From: Contact Centre (CRM) <contact@ribblevalley.gov.uk>
Sent: 14 July 2022 16:26
To: Planning
Subject: Planning Application Comments - 3/2022/0596 FS-Case-437079647

Planning Application Reference No.: 3/2022/0596

Address of Development: 27 Humber Street

27 Humber Street Longridge
External Lighting

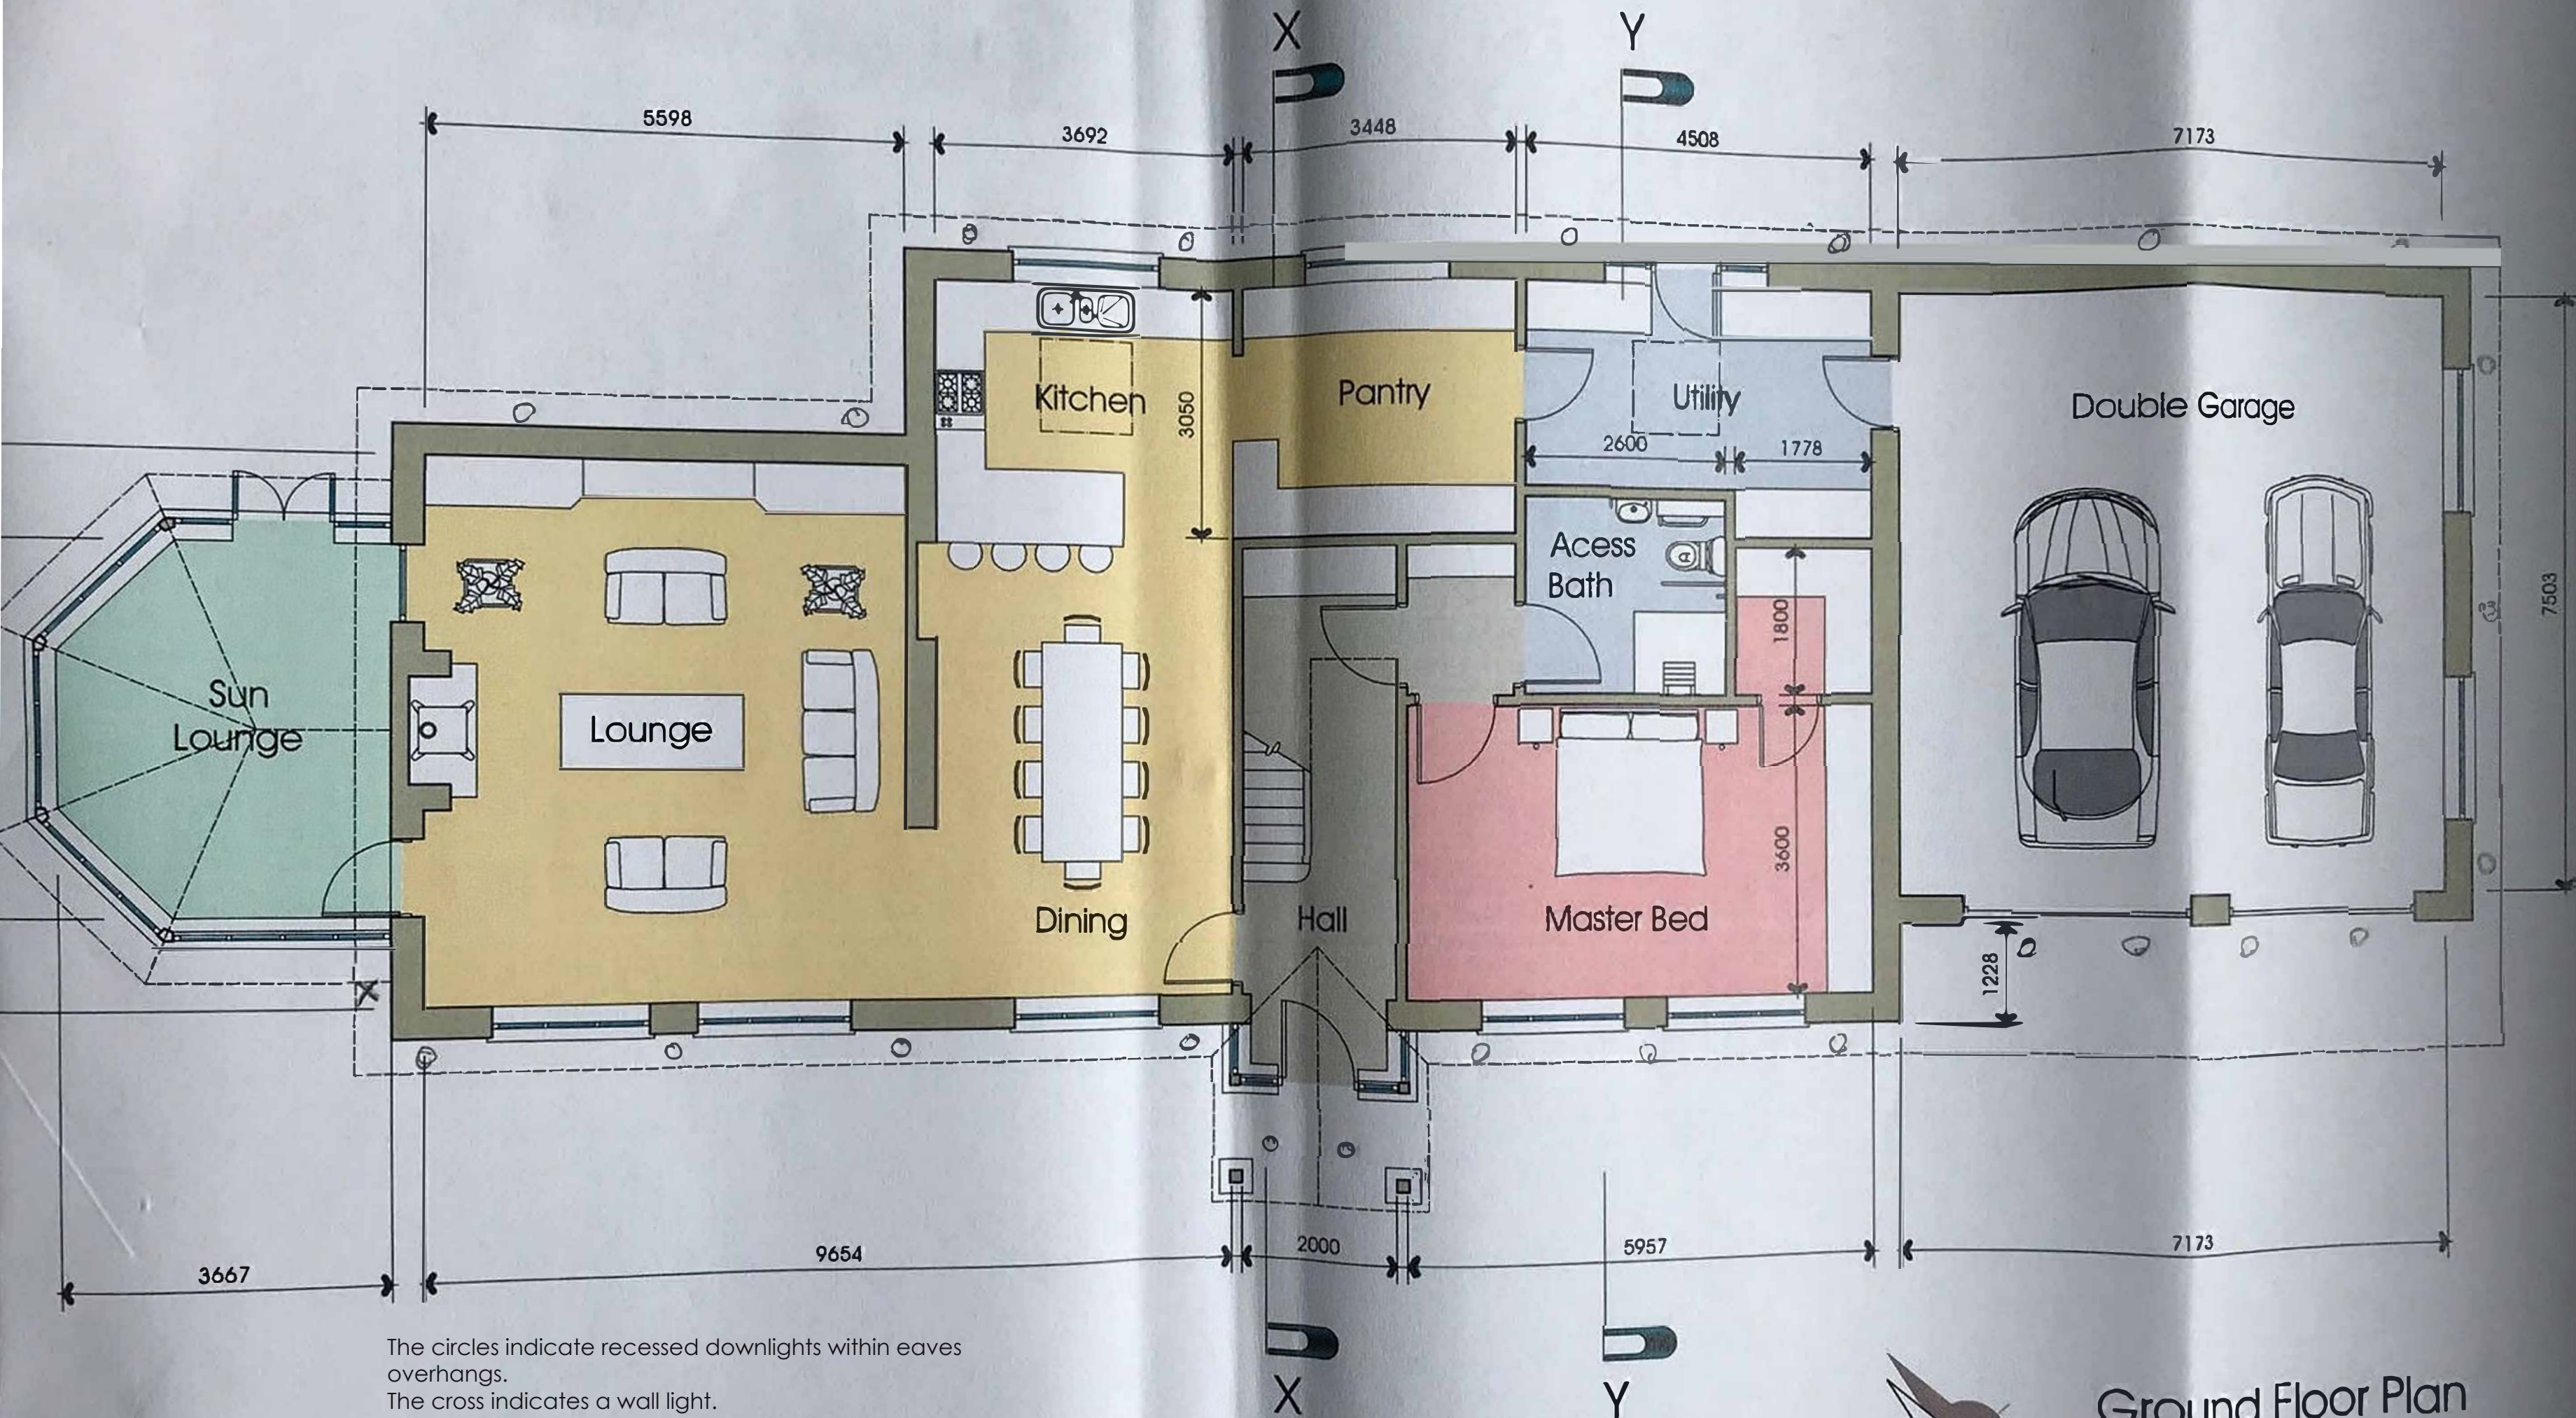
Comments: The lights that have been installed are a nuisance as can be clearly seen on the photos submitted with the application. The lights are designed to illuminate the render and thus make the house visible from [REDACTED]. We should not have our attention drawn to this very large building. The application seems to state they are for security, [REDACTED] amenity lighting. There are far too many lights on the building and [REDACTED]
